# COUNTY COUNCIL'S RESPONSE TO CONSULTATION ON THE FOLLOWING DEVELOPMENT PROPOSAL

**Application No:** 18/00584/REM-2

**Proposal:** Reserved matters application to 15/01012/OUT - Development of up to 48,308sqm of employment floorspace (Class B1c, B2, B8 and ancillary B1a uses), the siting of buildings to the south of the site, servicing and circulation areas, vehicular and pedestrian access from Skimmingdish Lane and landscaping.

**Location:** Land North East of Skimmingdish Lane, Launton.

Orig Title
CYCLE SHELTER DETAILS

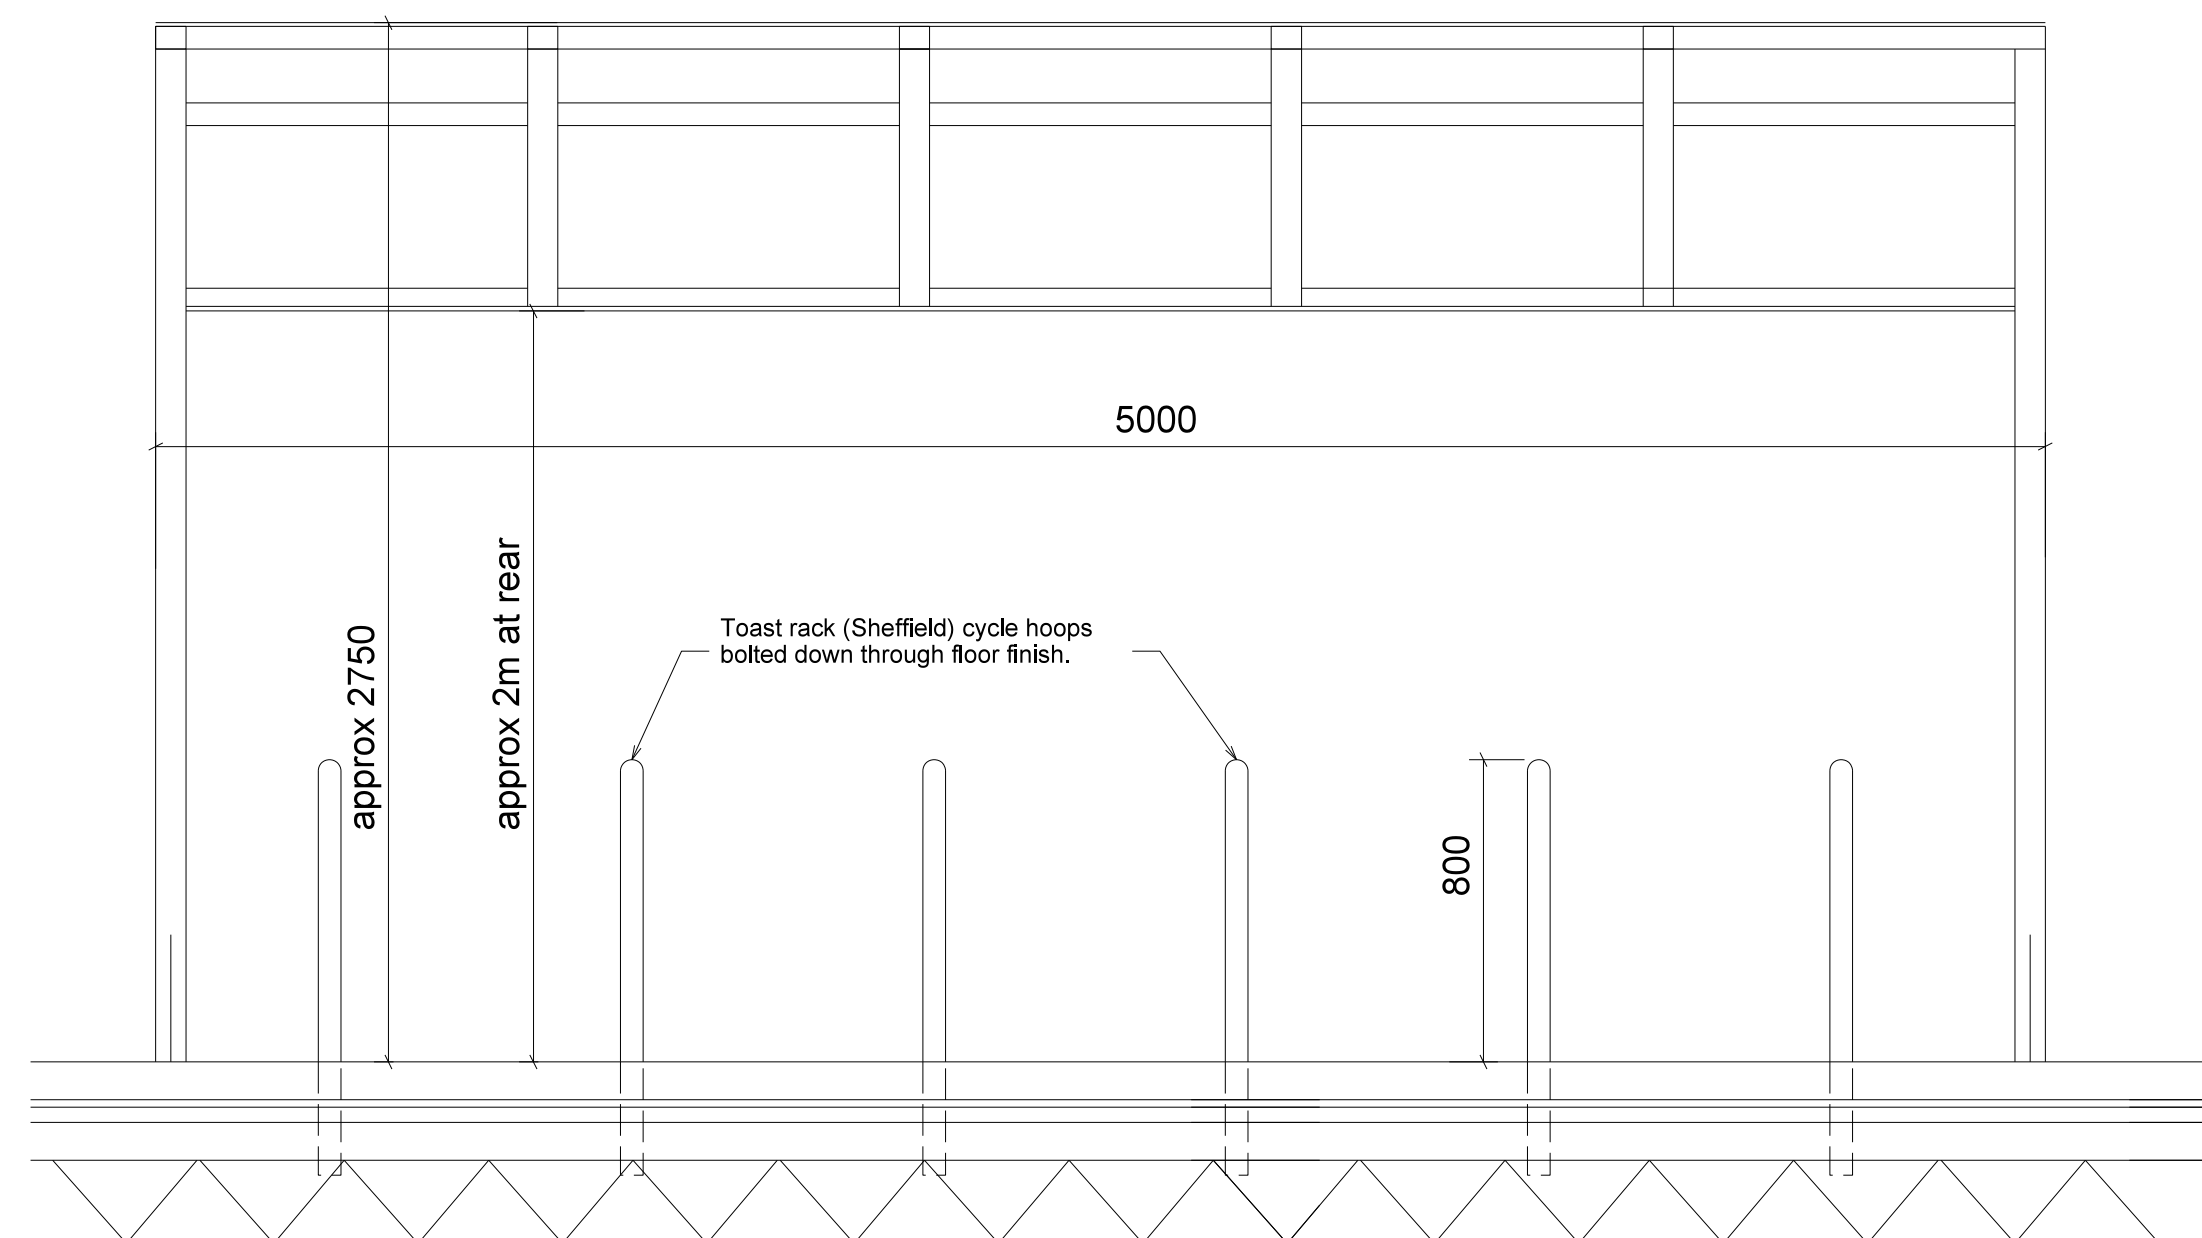
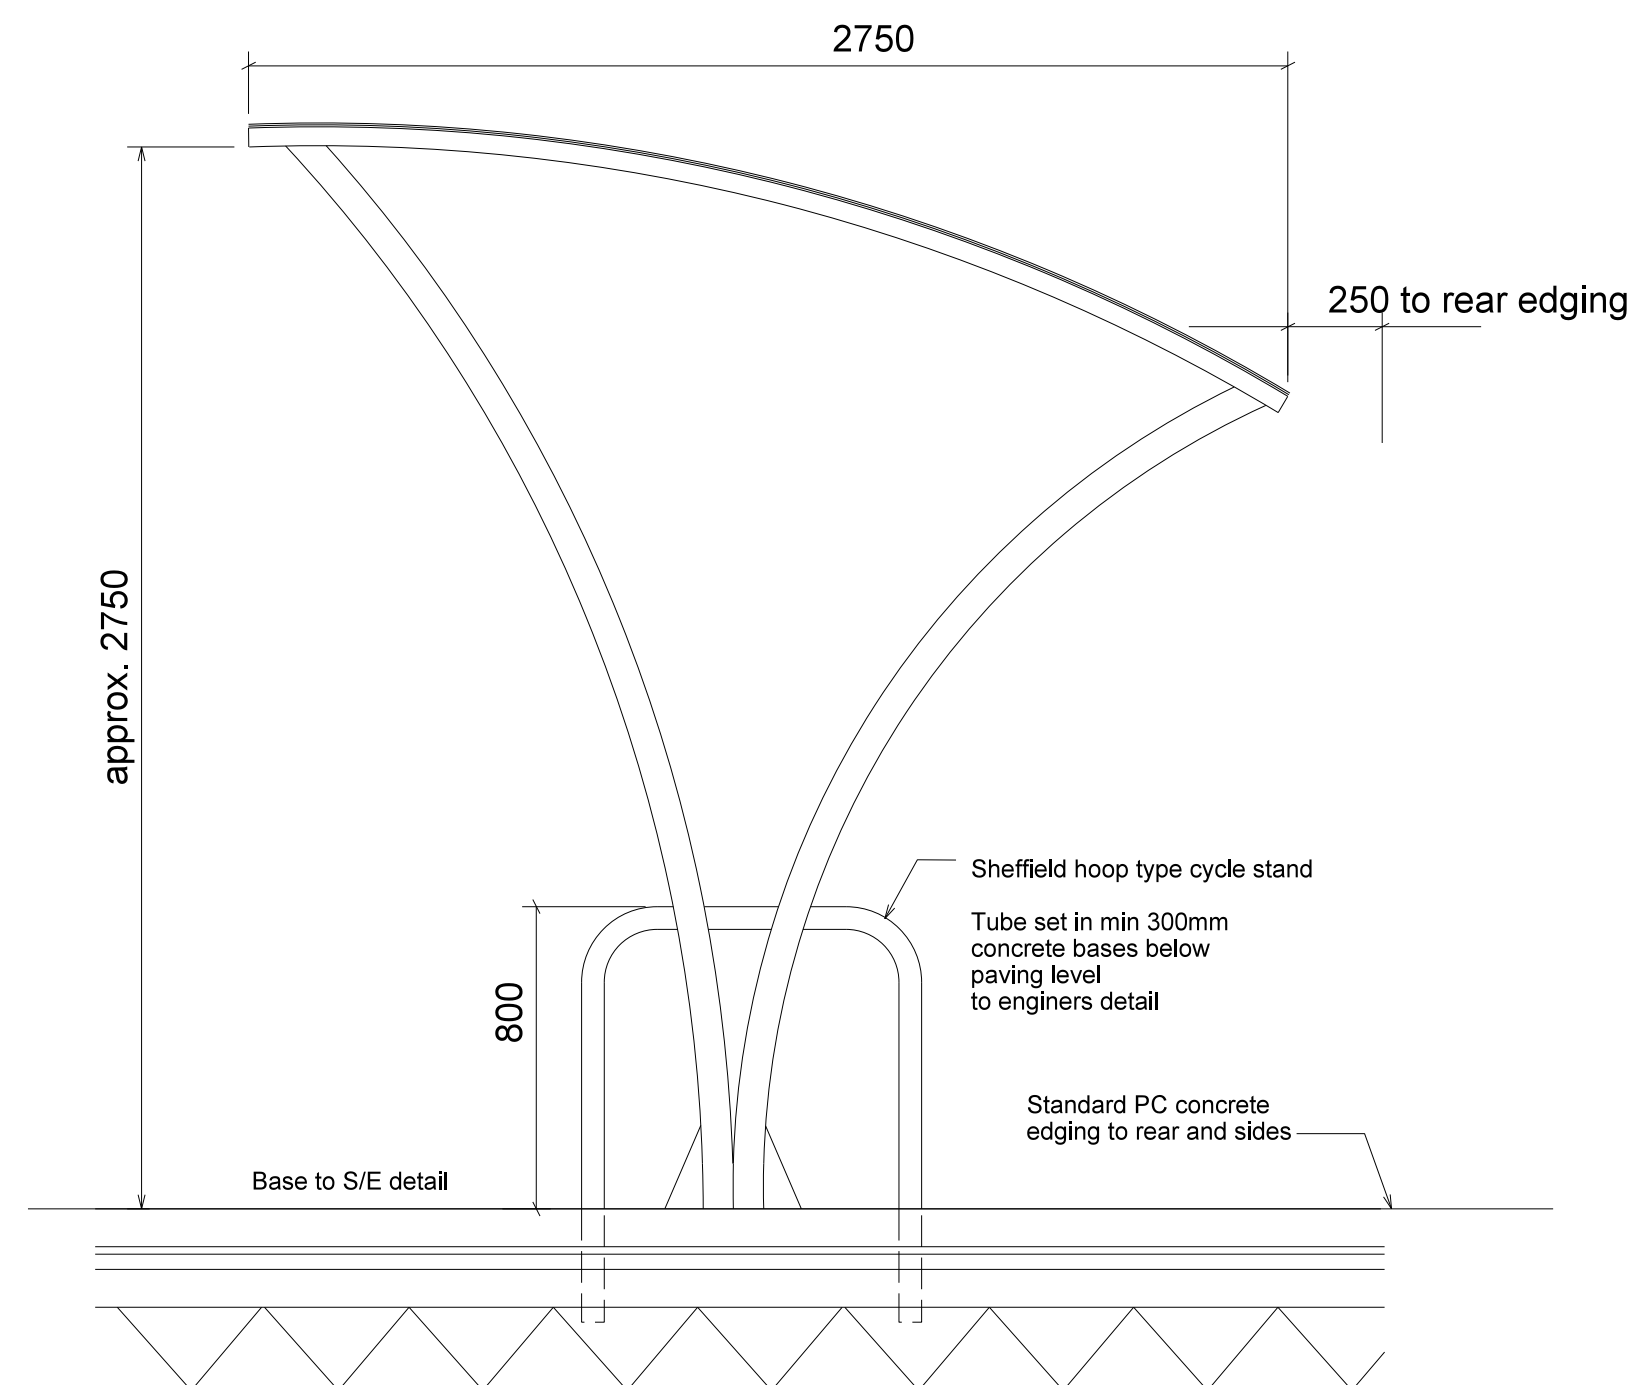
The reasons for my objection to 18/00584/REM have all been addressed in the amended documents. Cycle parking provision is not quite to the level that I requested, but on reflection I consider it to be adequate.
